FROM: Ian Gledhill **TO:** Arun District Council
FAO: Richard Temple

SUBJECT: Y/58/15/DOC - Application for approval of matters reserved by condition imposed under Y/68/09 relating to conditions 3 and 5- Stage One/Two Audit and Access.

Site 6, Felpham, West Sussex

TITLE:
SPORT PITCH ACCESS GHOST ISLAND OPTION

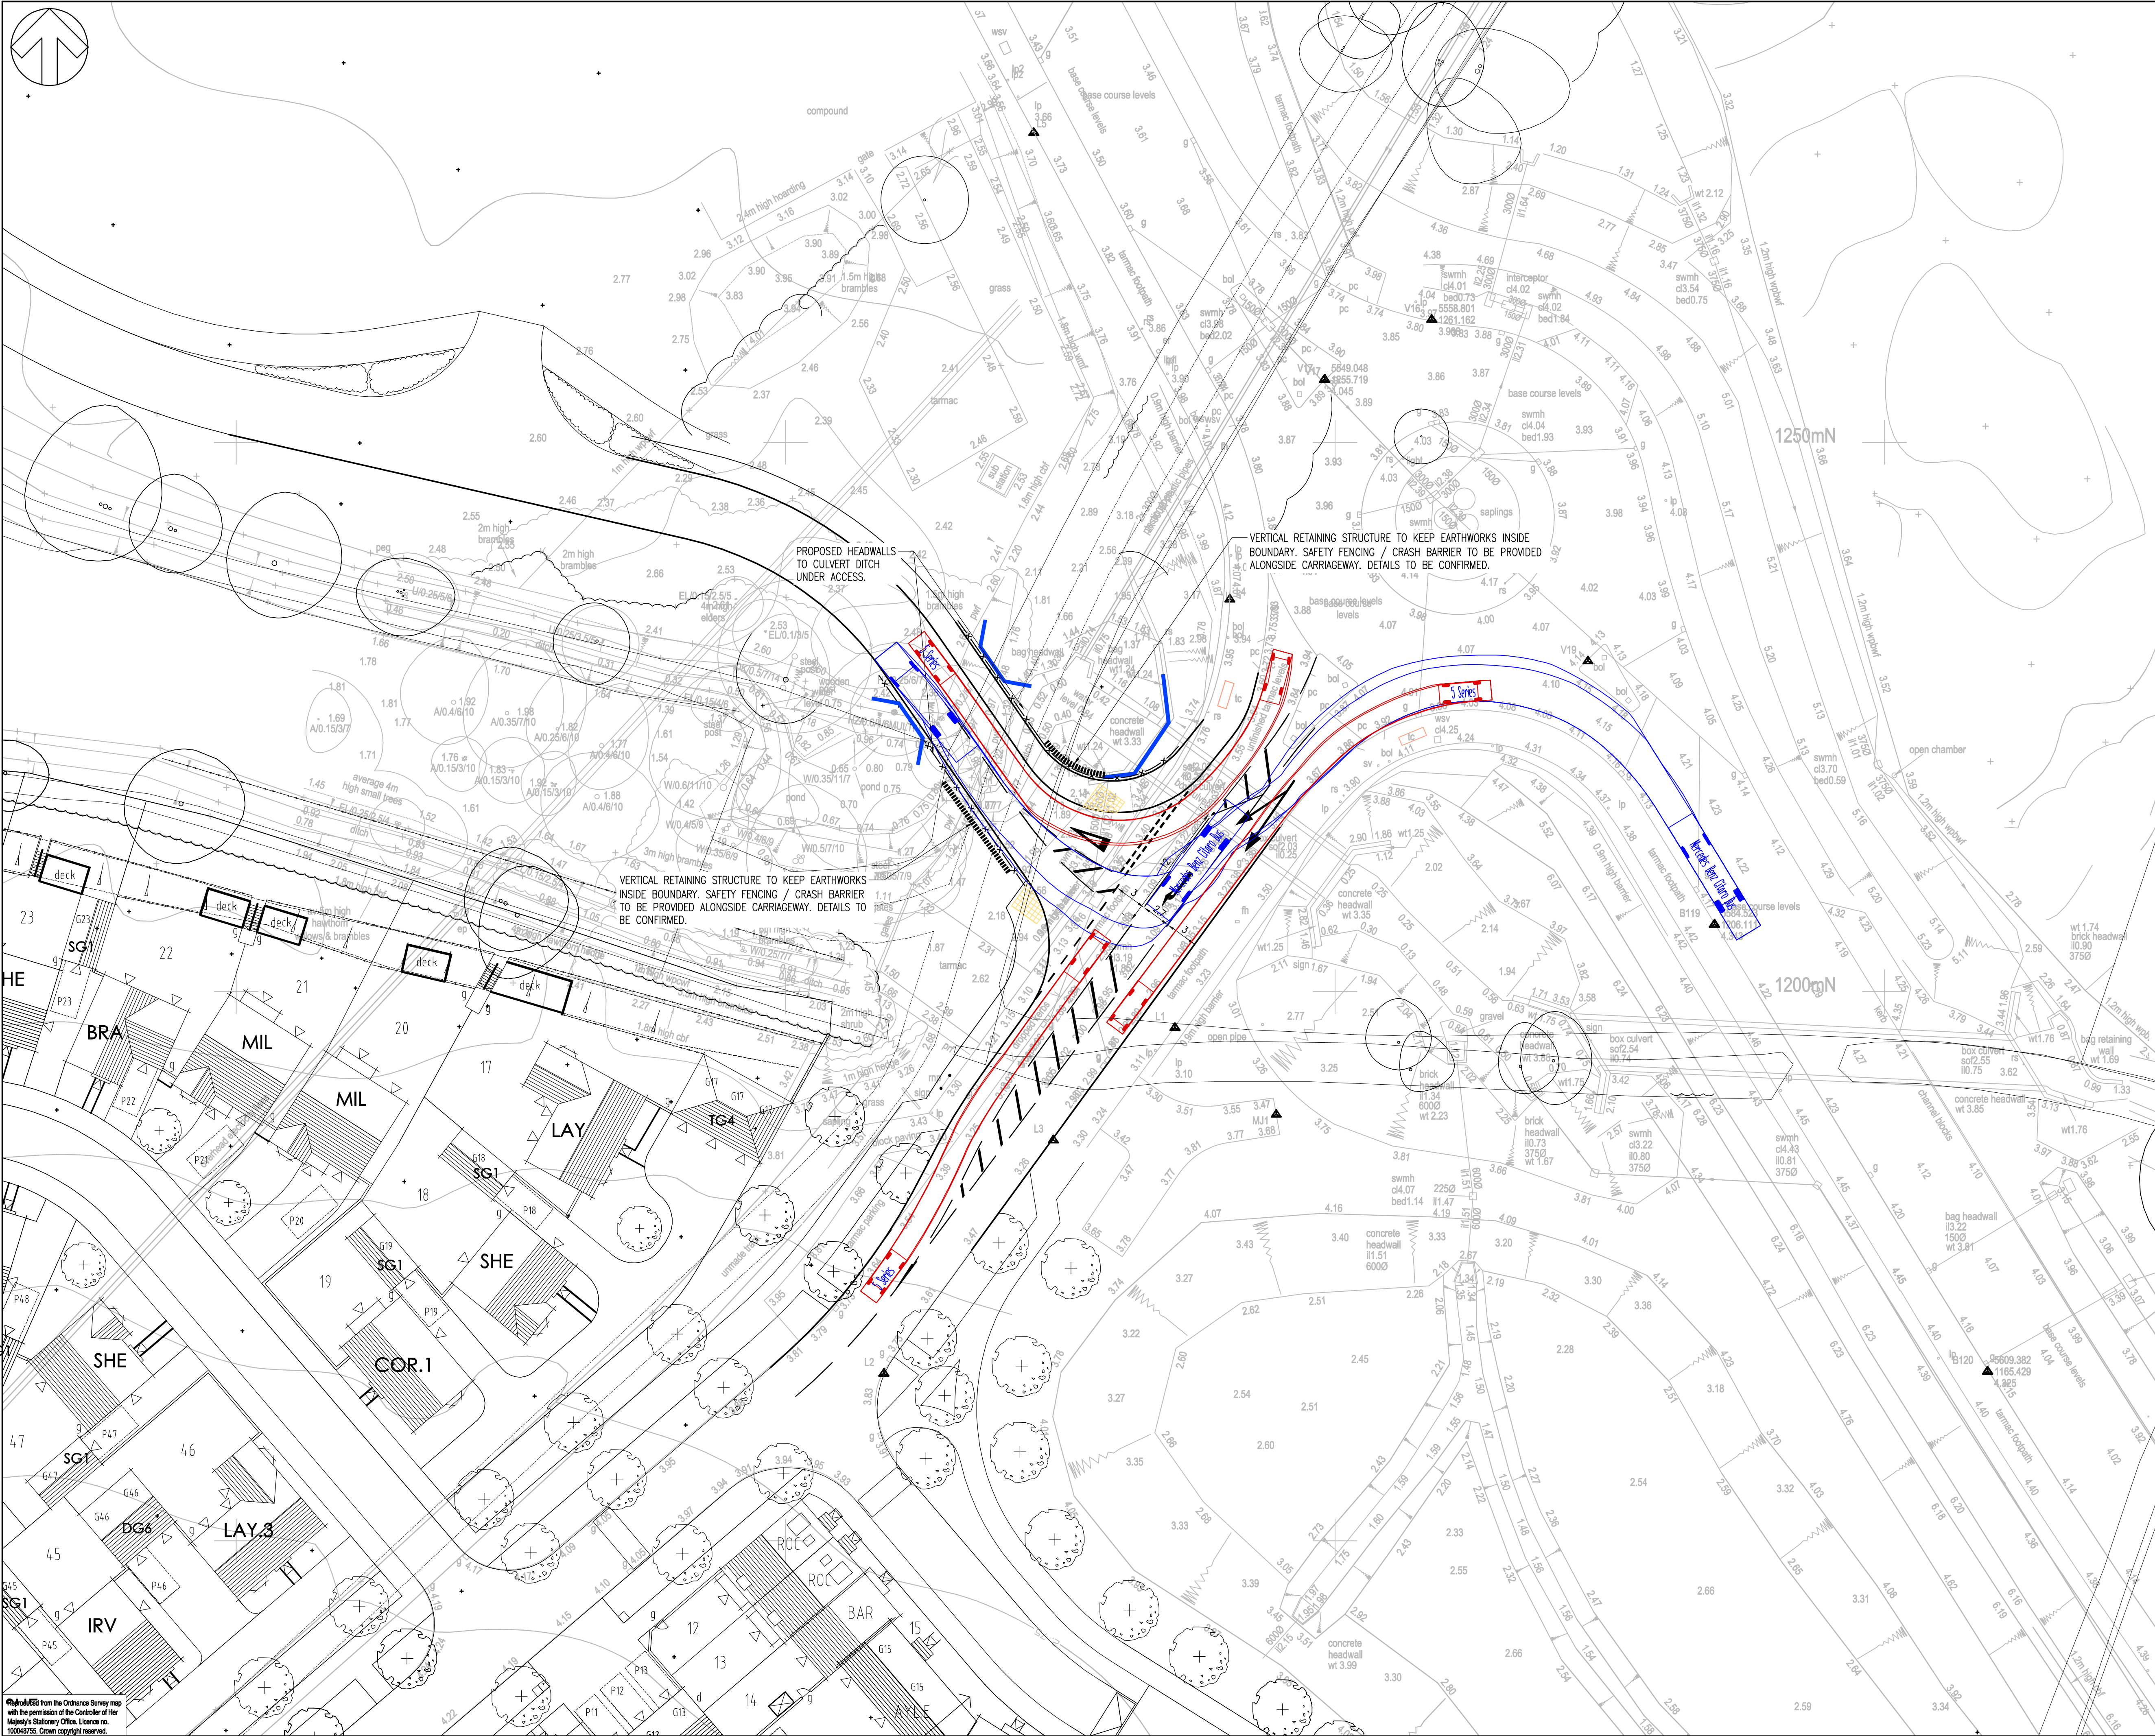
Condition 5 requires plans and details of the access to be submitted, and for the access thereafter to be constructed in accordance with the approved details. As part of Y/68/09 the access was shown as a simple priority junction. Various concerns were raised by the LHA regarding this arrangement. It was however accepted that the arrangement had been approved by way of the 2004 outline permission covering the wider residential site. Even so, the junction arrangement has now subsequently been altered primarily to suit the problems identified within the Stage One/Two RSA.

In principle, the arrangement now shown offers a potential betterment to that approved. The applicant would still need to demonstrate what standards have been applied to the revised design and how the design complies with these. In these respects a design audit or commentary of what standards have been applied would be appropriate. Advice on what should be included within this is detailed in the note appended to this response. If the scheme cannot comply with the relevant standards, departures may need to be sought. The LHA can advise the applicant accordingly on this process.

- Extend the right turning lane length northwards as much as possible towards the Relief Road Roundabout.
- The hatching within the access should be removed as this will potential encourage pedestrians to cross in two phases.
- The use of a bus as the design vehicle for the access is noted. In light of the facilities proposed, realistically will a vehicle of this nature be a frequent visitor to the site?
